**DELEGATED DECISION TO DETERMINE APPLICATIONS FOR
NON-MATERIAL AMENDMENTS**

Reference No: 2020/NM/92080/W

Site Address: 120, Laund Road, Salendine Nook, Huddersfield, HD3
3TY

Description: Non material amendment to previous permission
2019/90486 for demolition of existing dwelling and
erection of 7 dwellings

SOUTH ELEVATION

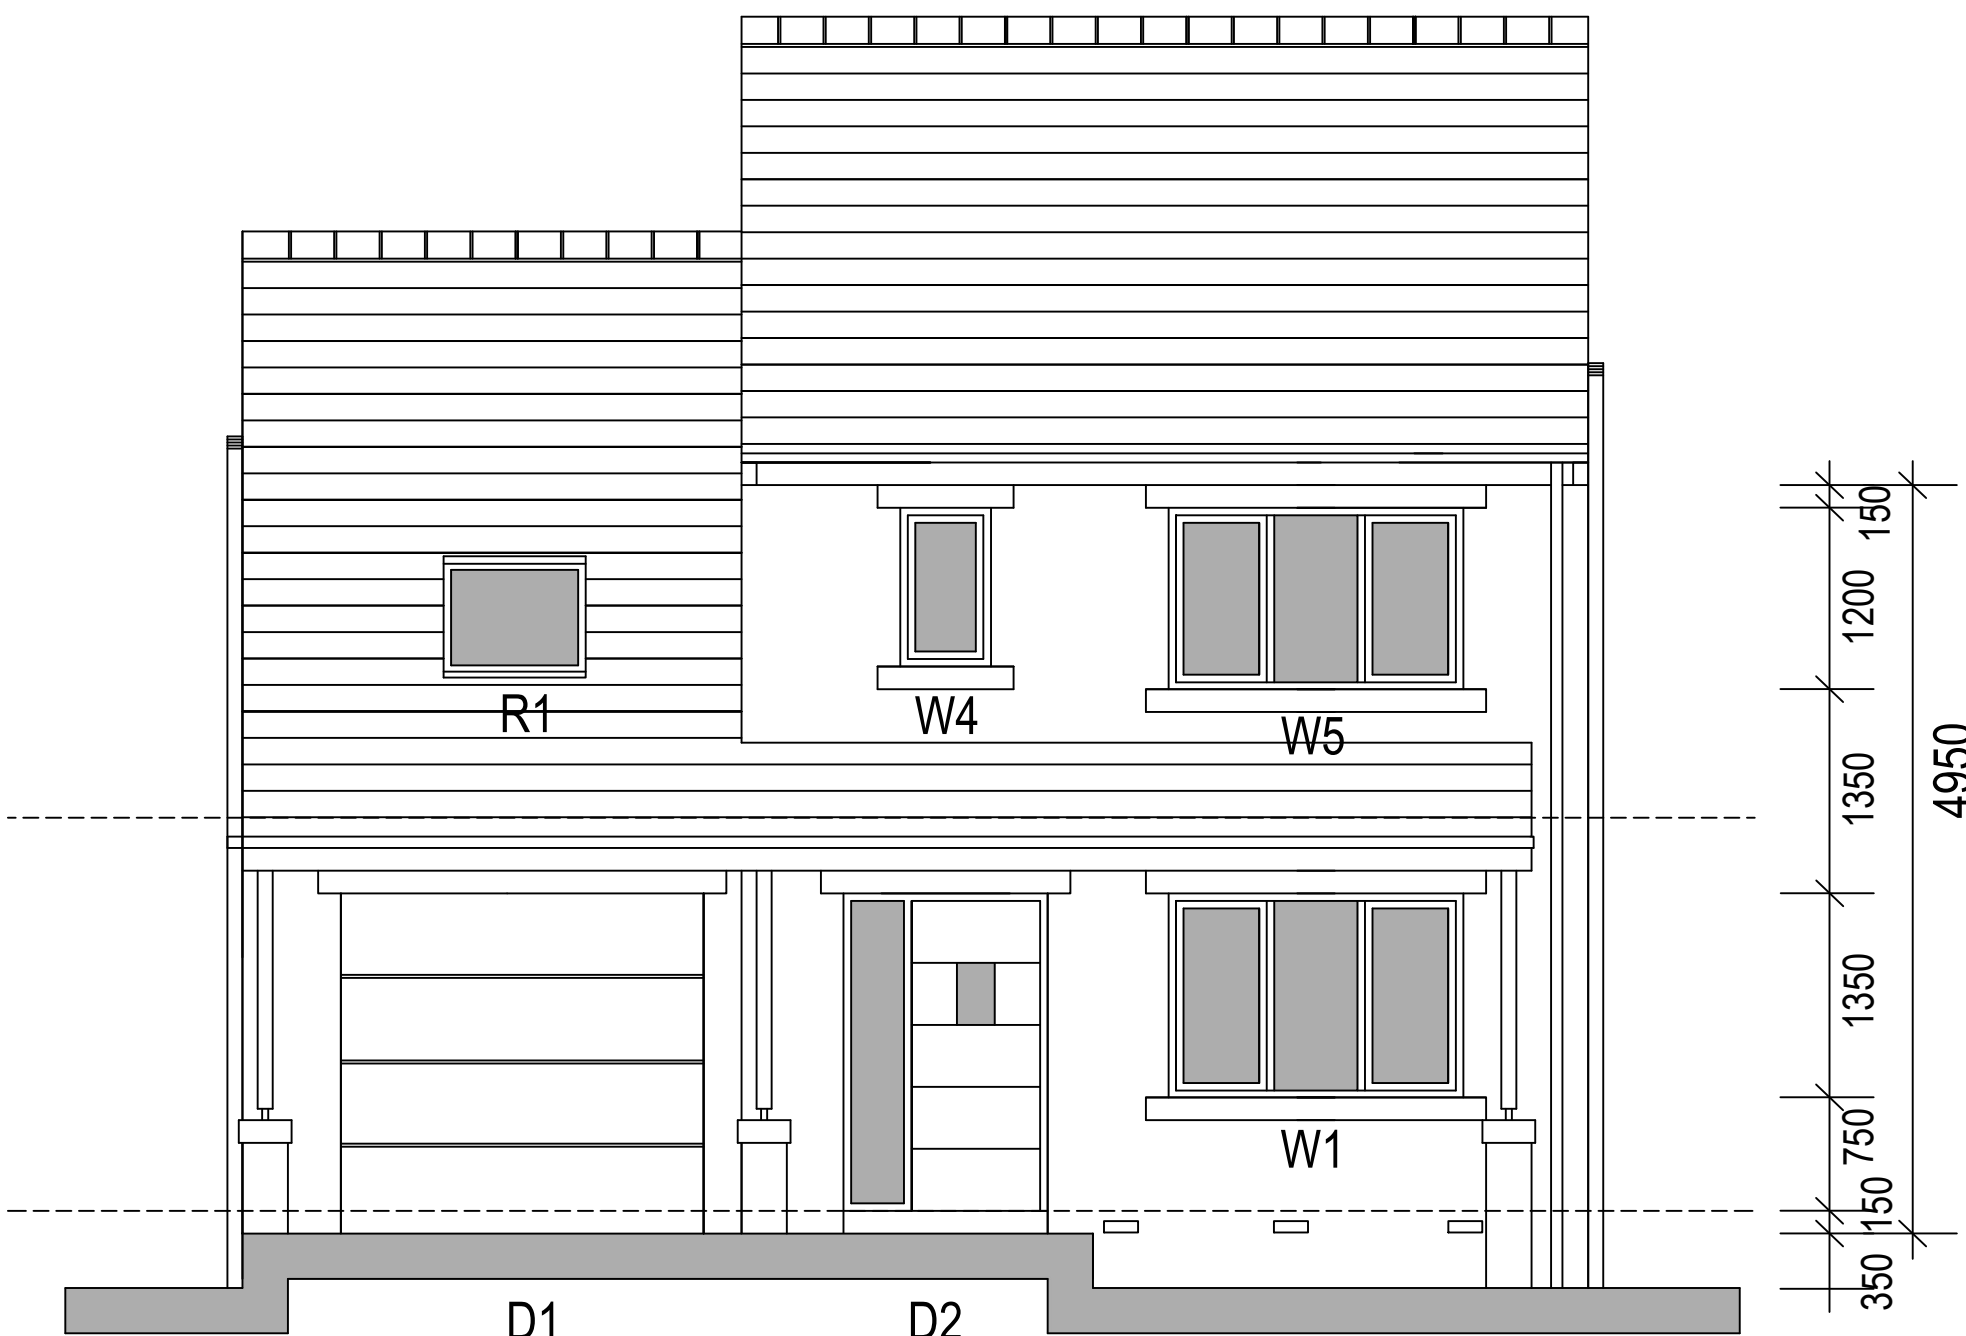
- The increase in overall height of plot 2 by 350mm.

Yes. Whilst the proposal would increase the overall height of the building it is considered that a 350mm increase would be minor when compared to the overall height of the dwelling which would be 8.1 metres.

No, the increase in height would not have a material affect the appearance of the dwelling and it would retain an acceptable design which would preserve the character and appearance of the dwelling and wider local area and would not lead to any additional detrimental impact on living conditions.

No. The alteration is considered to be inconsequential; whilst the height of the dwelling would be increased, it is not considered that the very limited overall scale would not lead to a detrimental overshadowing or overbearing impact on any of the adjacent properties.

No, whilst the overall height is to be increased by 350mm it is not considered to 'materially' larger and as set out above the proposal is considered to have an acceptable impact on visual and residential amenity.

- The increase in overall height of plot 2 by 350mm.

This amendment is set out on the following drawings, Site Plan Dwg. No. 02 Rev B, Proposed Elevations Dwg. No. 11 Rev A, Proposed Floor Plans Dwg. No. 10 Rev A.
